24th December 2013

Planning Application A/134/13

I write on behalf of Save Angmering Village (SAV) to **OBJECT** to the above outline planning application for demolition of Broadlees, and erection of up to 27 x 2 bed age restricted cottages, a 60 bed care home, laundry room, managers cottage and guest suite, with associated car parking, in its current form.

Proposed Site Plan

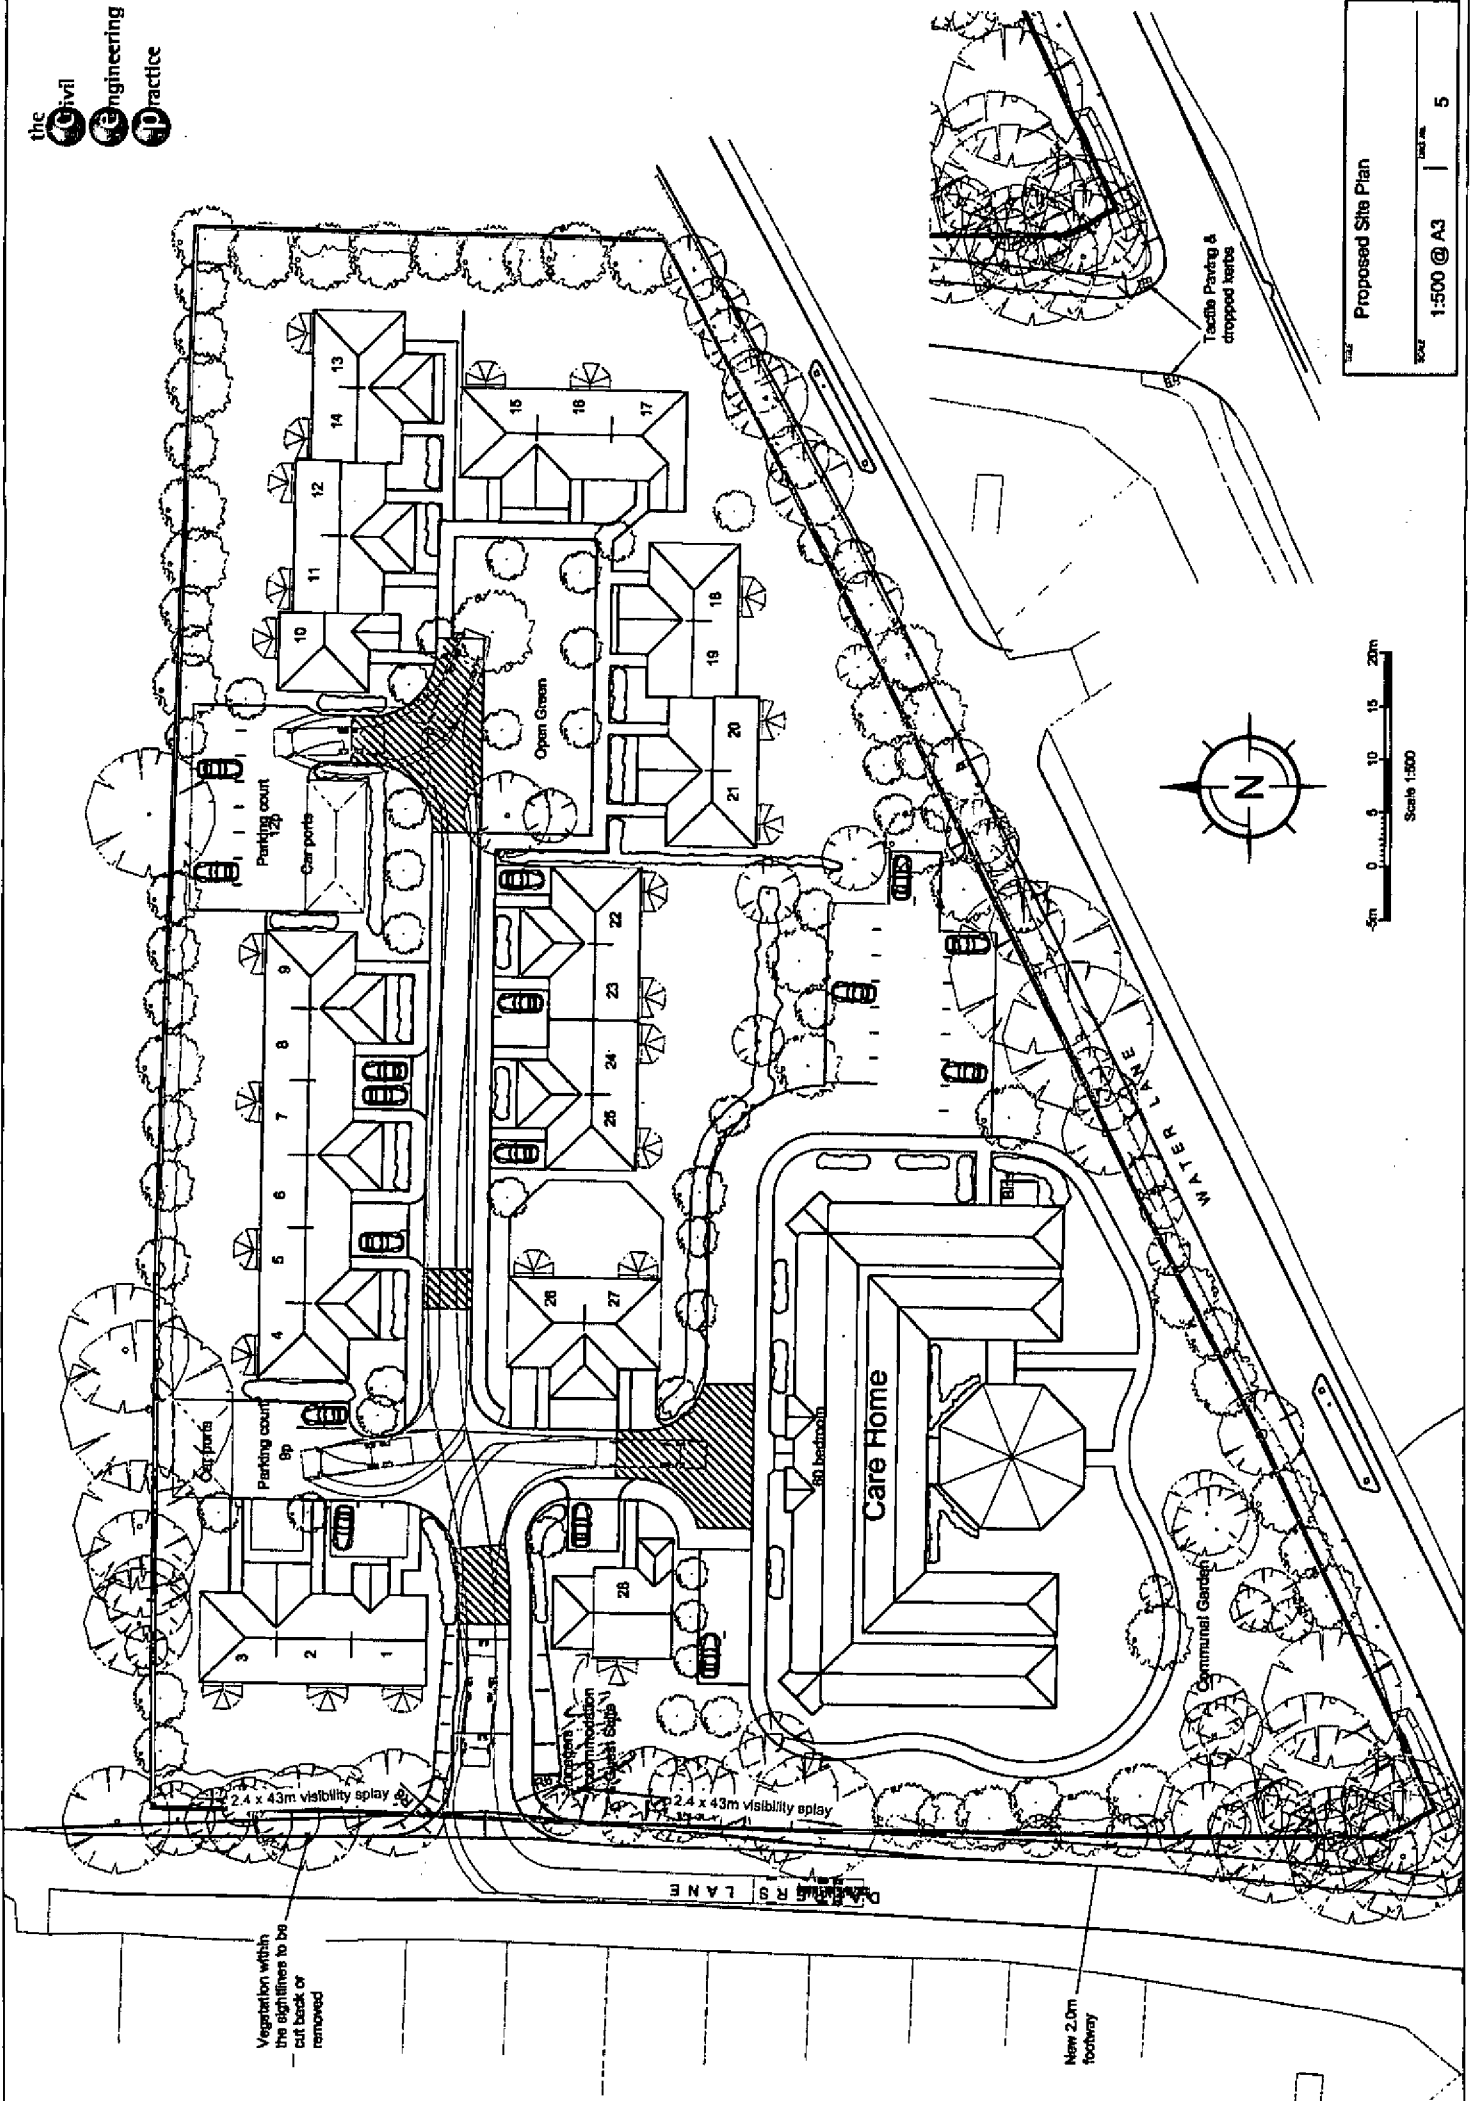
There do not appear to be sufficient parking spaces for the size of the development. The 60 bed Care Home only has 19 car parking spaces allocated for service vehicles, staff and visitors. This appears inadequate when compared with an equivalent 61 bed Care Home facility in the south of Angmering which has 26 bays.

The allocation of only 31 spaces for the 27 x 2-bed cottages assumes only one vehicle per dwelling, leaving one assumes, 4 spaces for visitor parking.

The age restricted entry criteria is for only 1 person in a couple to be 55+. With the retirement age rising, there is a strong possibility that an increasing percentage of residents will remain in employment and commute for at least another 10 years. Therefore it is reasonable to assume that a percentage of occupants will have more than 1 (one) vehicle. This needs to be taken into account and the number of spaces reassessed to avoid on-street parking. .
